Our ref: SSD-65924461

22 April 2025

Subject: Stephen Road Multi-level Warehouse, Banksmeadow - Additional Matters for Submissions Report

Department's Request for Information

4 SHADOW DIAGRAM - WINTER SOLSTICE - 9am 1 : 1500

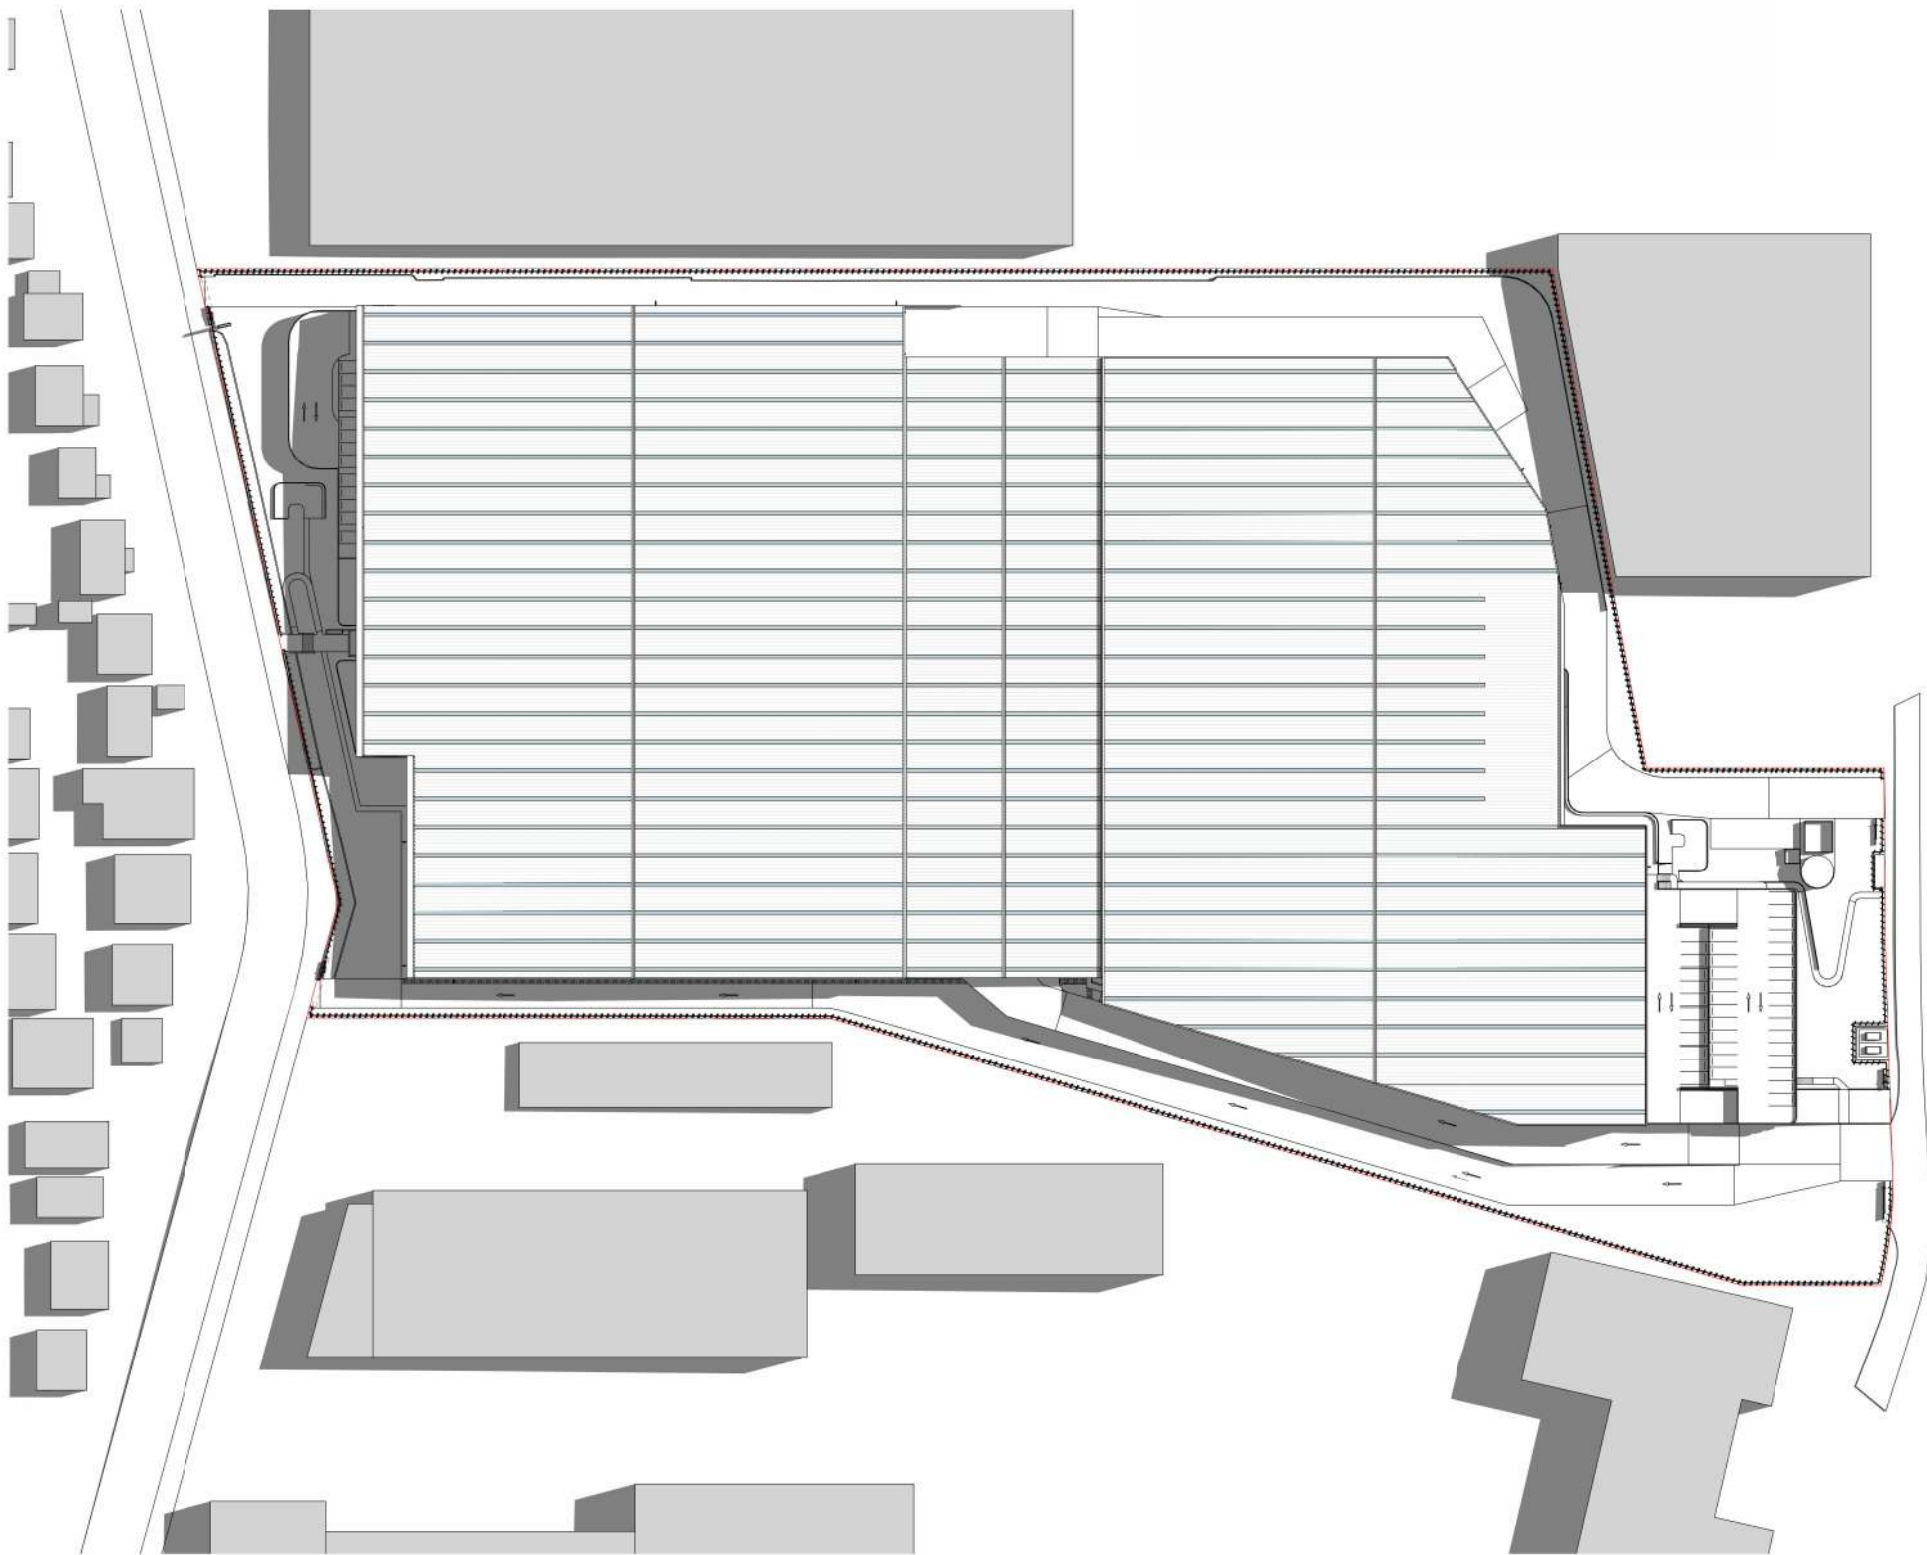
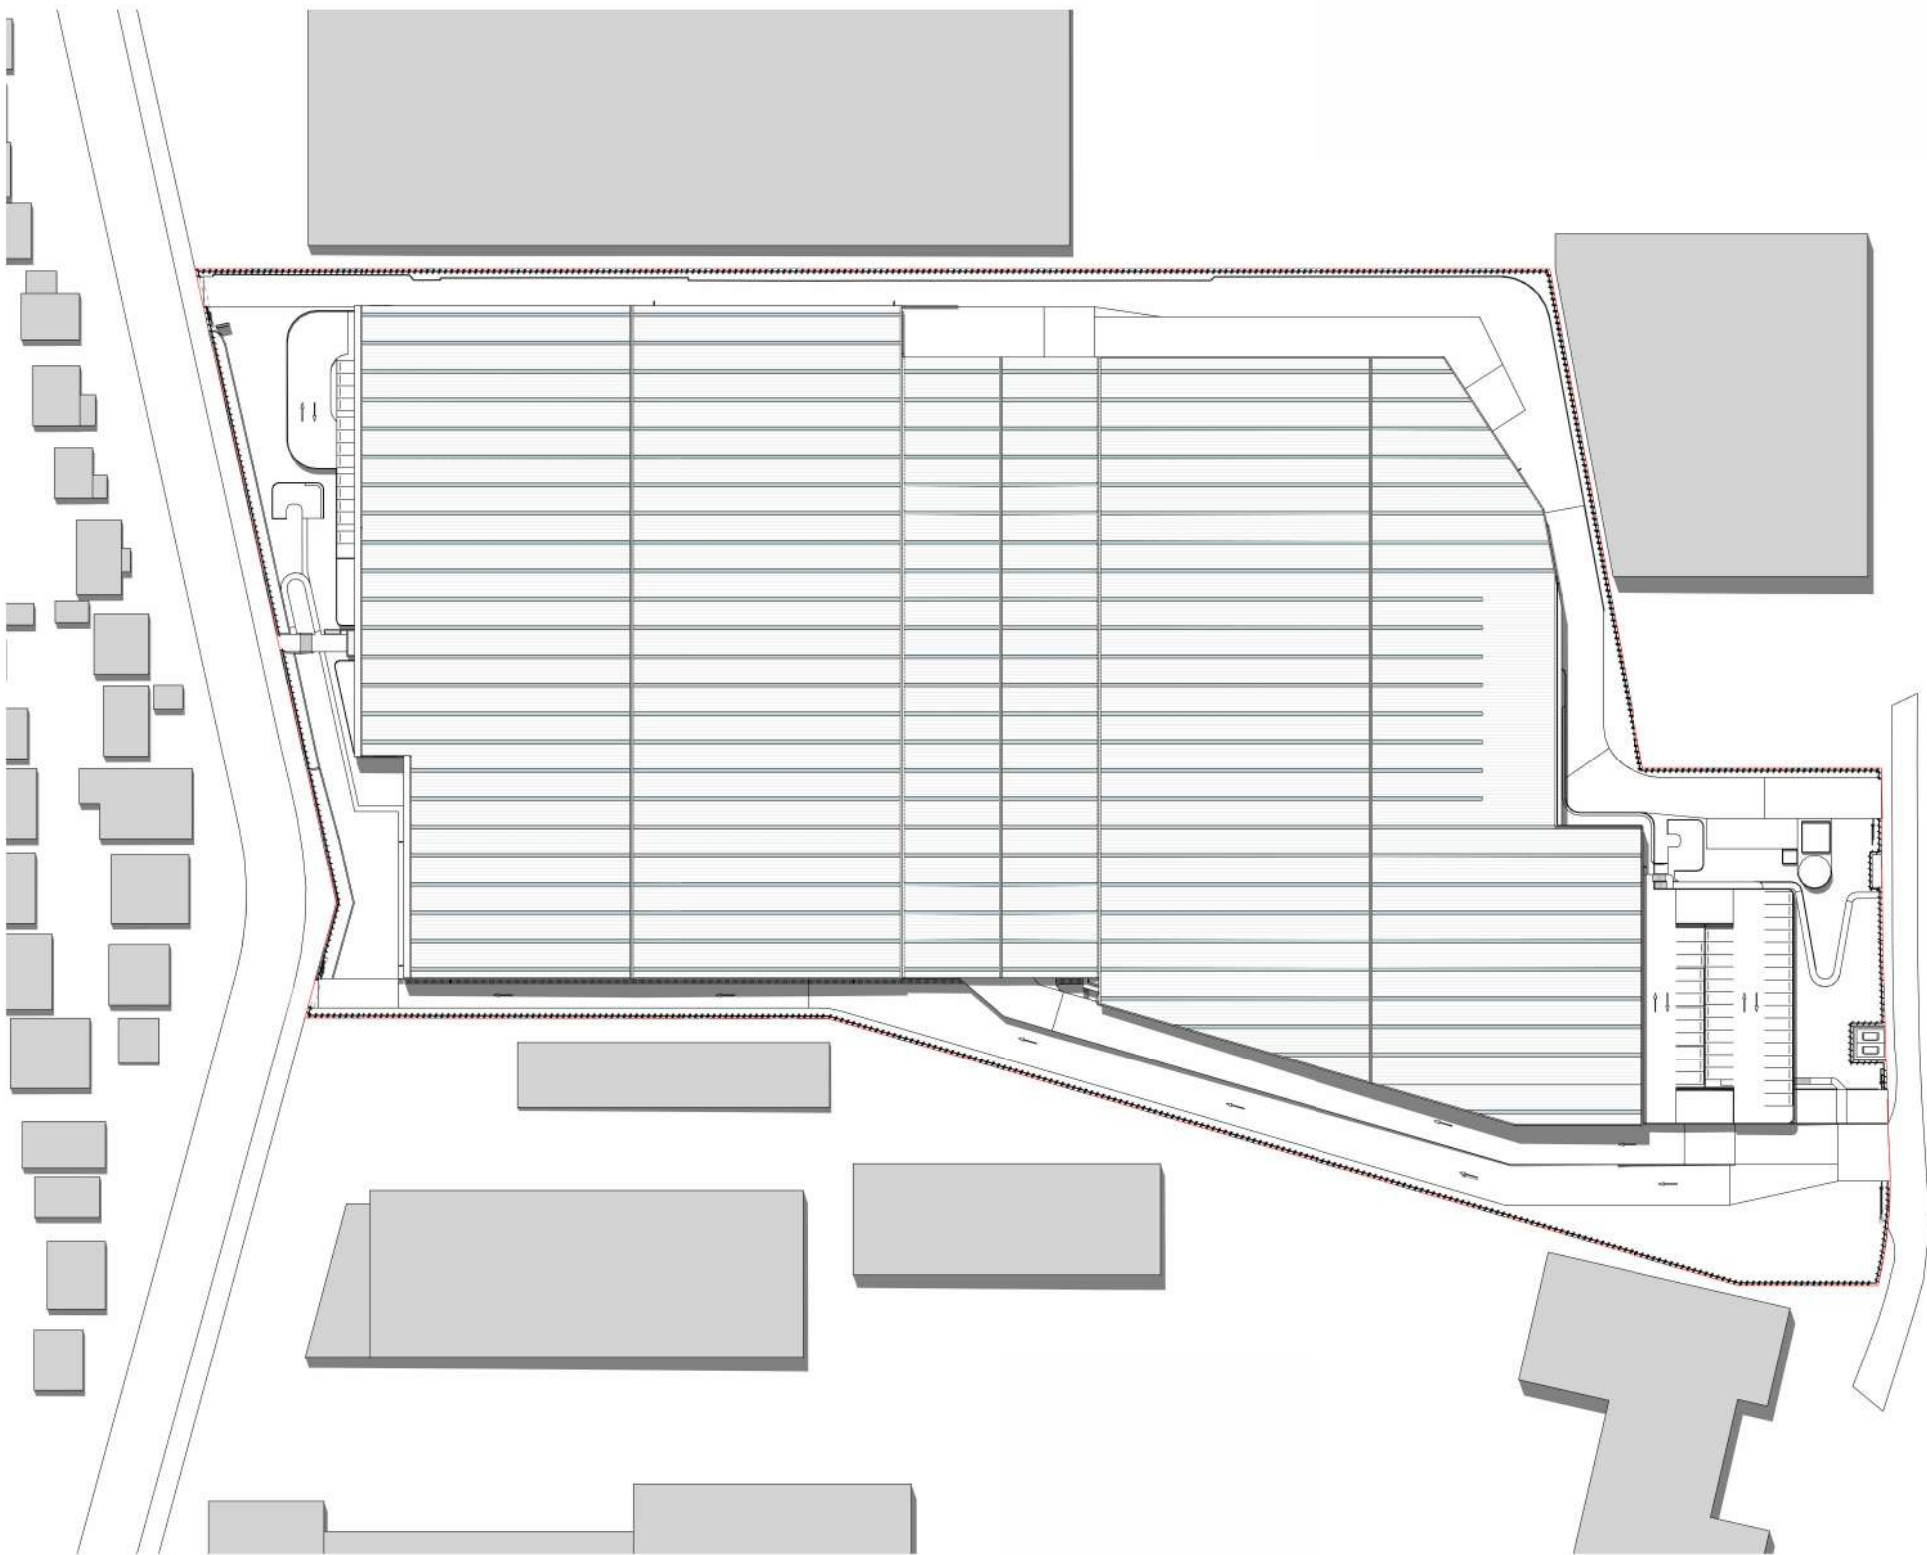
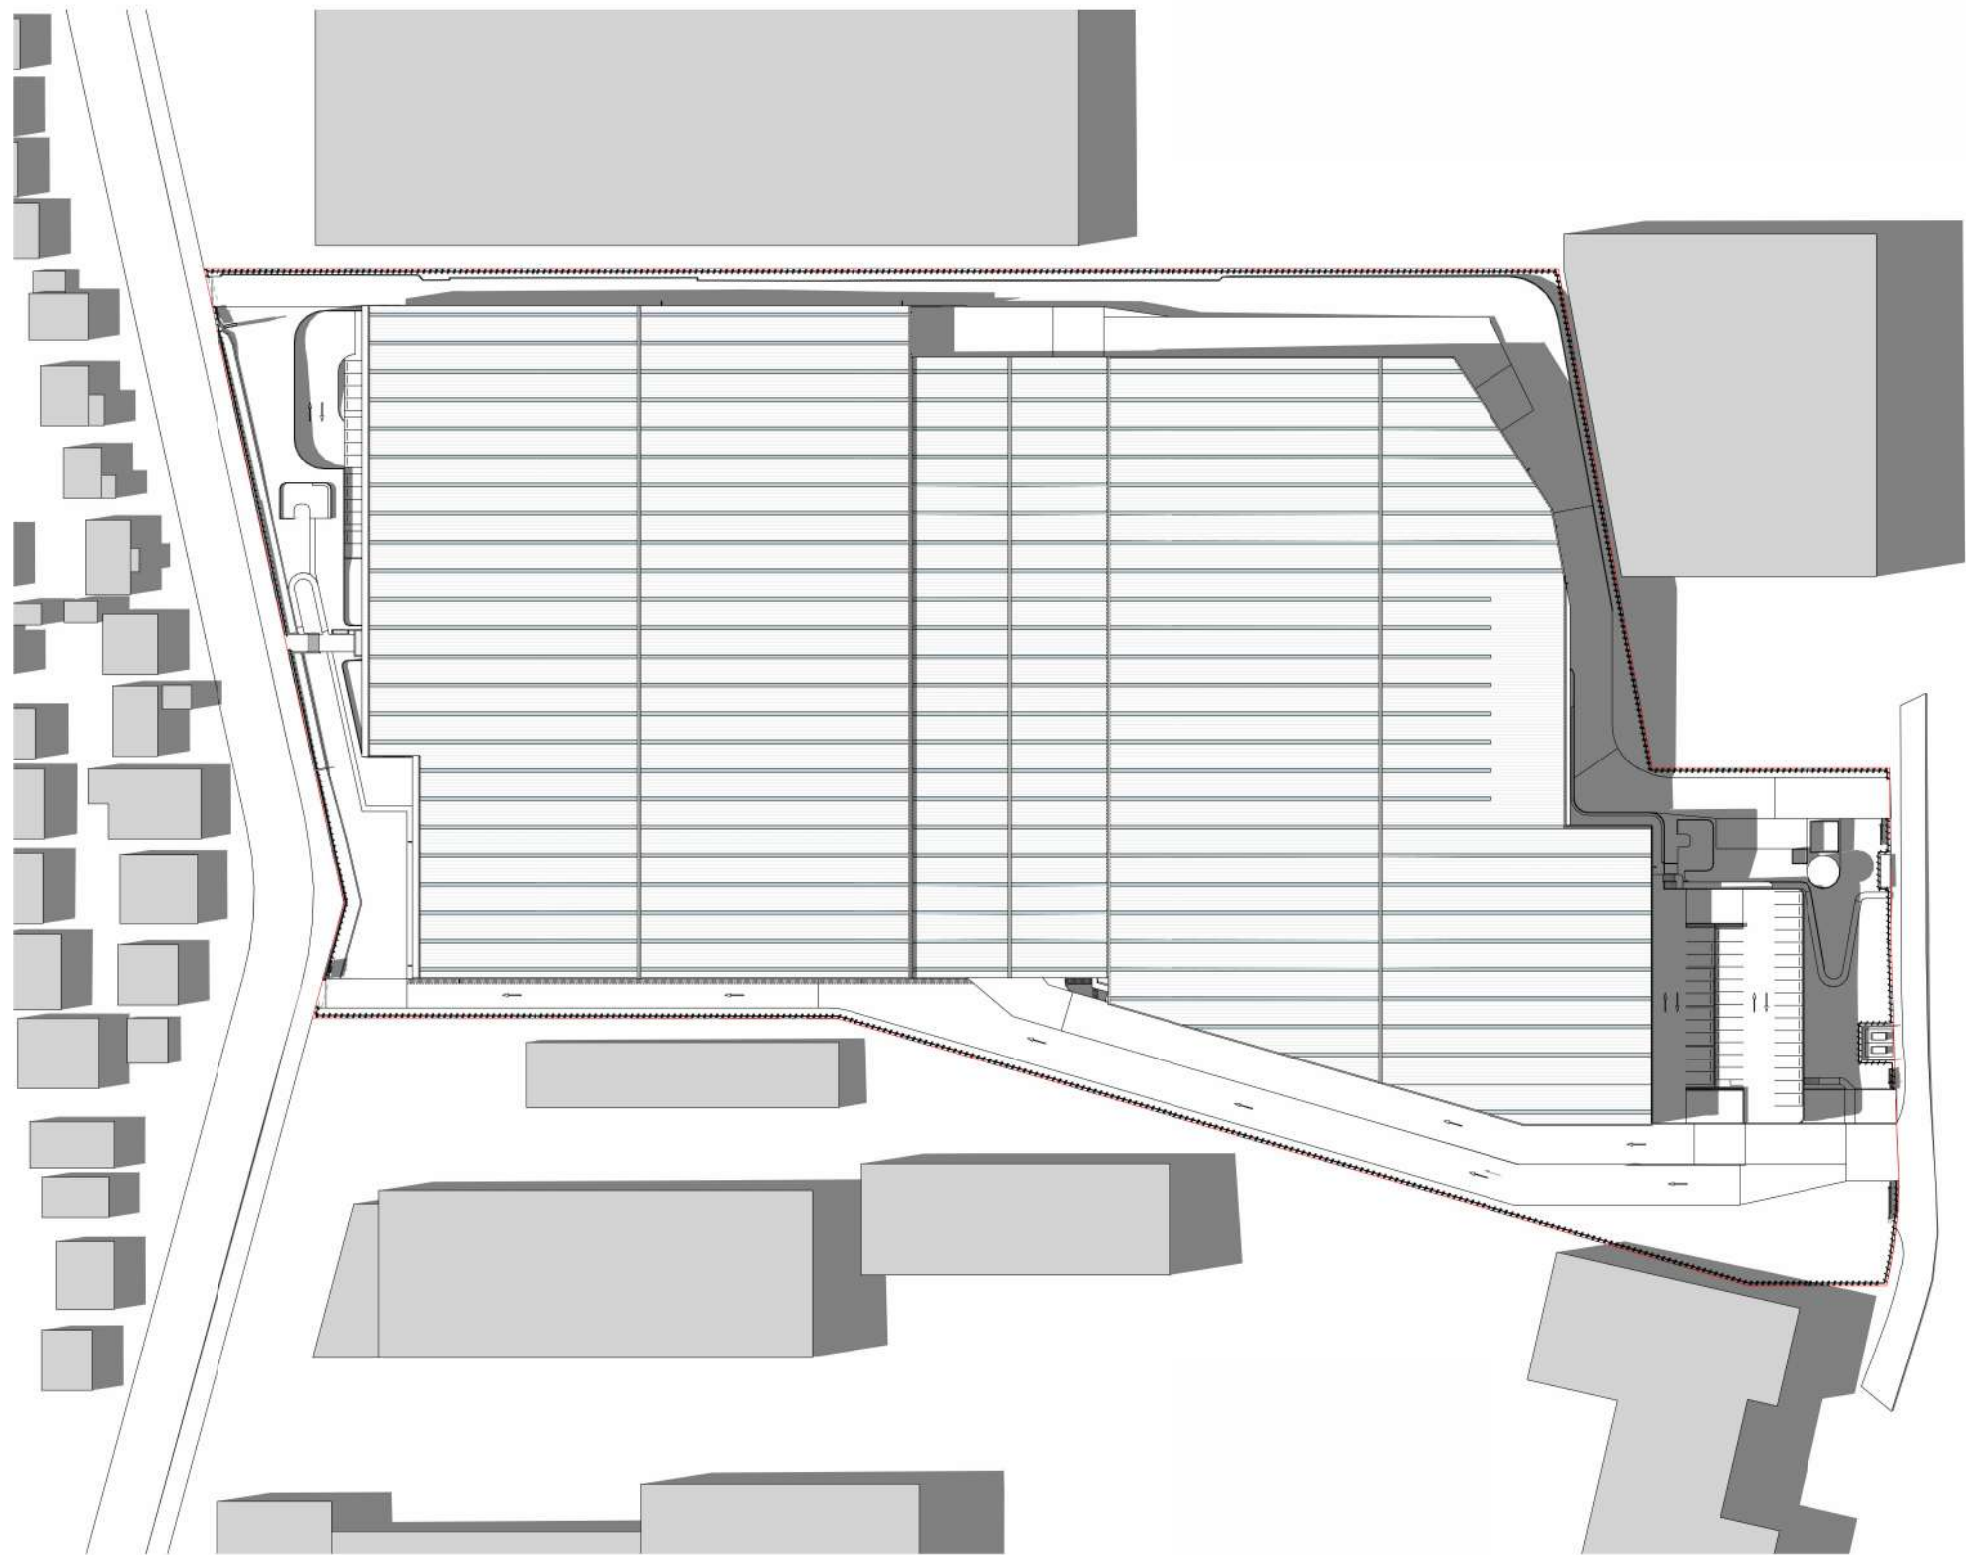
4. The Department raises concerns over the shadowing impact the proposal will have on residential properties opposite the site on Stephen Road, particularly during winter mornings. Revising the buildings interface with Stephen Road by reducing the scale of the building will likely assist in minimising the impact on solar access to the sensitive receivers.
